## **HINCKLEY NATIONAL RAIL FREIGHT INTERCHANGE**

### **The Hinckley National Rail Freight Interchange Development Consent Order**

### **Applicant's response to deadline 3 submissions [Part 1 - BDC]**

Document reference: 18.13

Section H-H: South-eastern boundary with Freeholt Wood

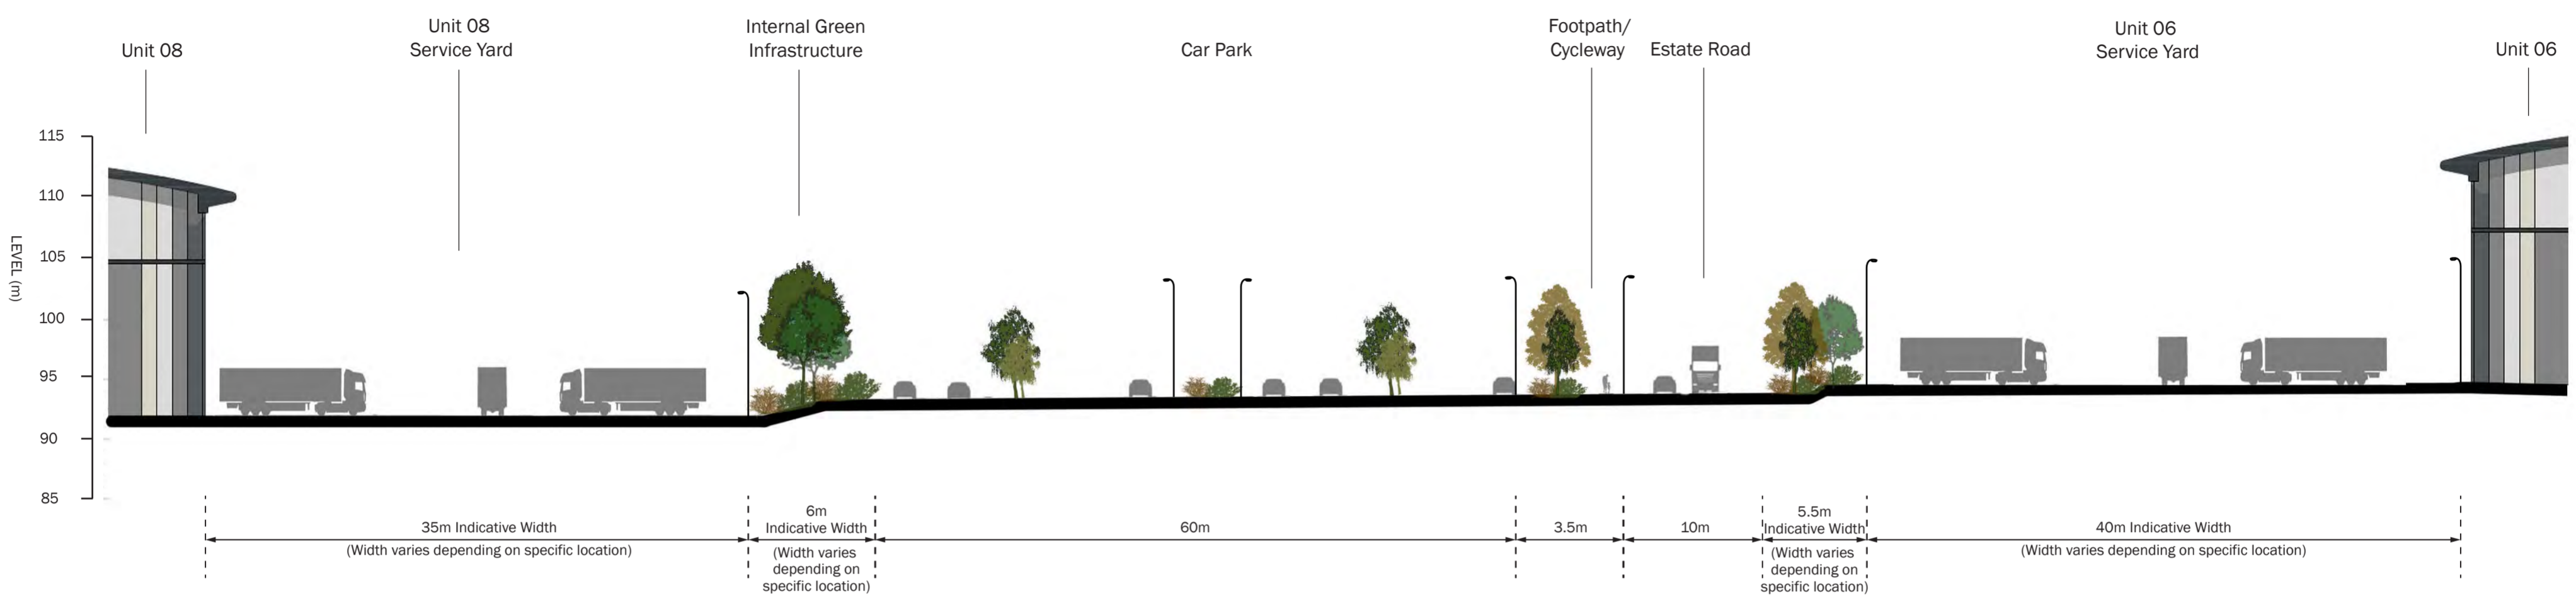
34	BDC state that the need for a phased assessment approach needs to be further explored as the phased construction phase may result in habitat being created/enhanced in advance of loss, improving the overall BNG score.	Agreed.	No further comment. Agreed.	Noted
<b>Impact B: Potential Impacts on Human and Ecological Receptors</b>				
35	BDC state that increases in ambient pollutant concentrations will be experienced at a number of human and ecological receptors within BDC and the wider assessed areas.	Acknowledged; however these increases are predicted to be negligible in accordance with relevant guidance and the current relevant air quality objectives.	See comments on air quality.	A meeting was held between the Applicant, BDC and HBBC on 20.11.23 in which Air Quality Impacts on Freeholt Wood were discussed. Following this the Applicant a revised Illustrative Landscape Section plan is submitted as part of the Applicant's D4 submissions (Figure 11.17, document reference 6.3.11.17A) which shows indicative buffer widths in key locations. The figure now also includes a section next to Freeholt Wood.

36	BDC has concerns regarding the predicted impact on the Free Holt Ancient Woodland located immediately adjacent to the new link road, where a percentage change relative to the lower critical load (10 kg N ha-1 year-1) of up to 1.4% is predicted.	The Air Quality ES Chapter (document reference: 6.1.9, APP118) provided the changes in nitrogen deposition at the Freeholt Ancient Woodland and the significance of these impacts were considered in Ecology ES Chapter 12 (document reference: 6.2.12, APP-121). The Ecology and Biodiversity Chapter states that although there will be some increase at ecological receptors (including Freeholt Wood) above 1% of the critical load, these do not exceed an increase of more than 1% of the current baseline deposition without the HNRFI. Therefore, these increases would not be considered significant in EIA terms. The figure of 10 kg N ha-1 year-1 on woodland habitat is taken from Air Pollution Information System (APIS)	See BDC's Written Statement of oral case at ISH3 on this matter.	A meeting was held between the Applicant, BDC and HBBC on 20.11.23 in which Air Quality Impacts on Freeholt Wood were discussed. Following this the Applicant has provided a revised Illustrative Landscape Section plan submitted as part of the Applicant's D4 submissions (Figure 11.17, document reference 6.3.11.17A) which shows indicative buffer widths in key locations. The figure now also includes a section next to Freeholt Wood which shows an indicative buffer width of approximately 45m between Freeholt Wood and A47 link road at closest point.
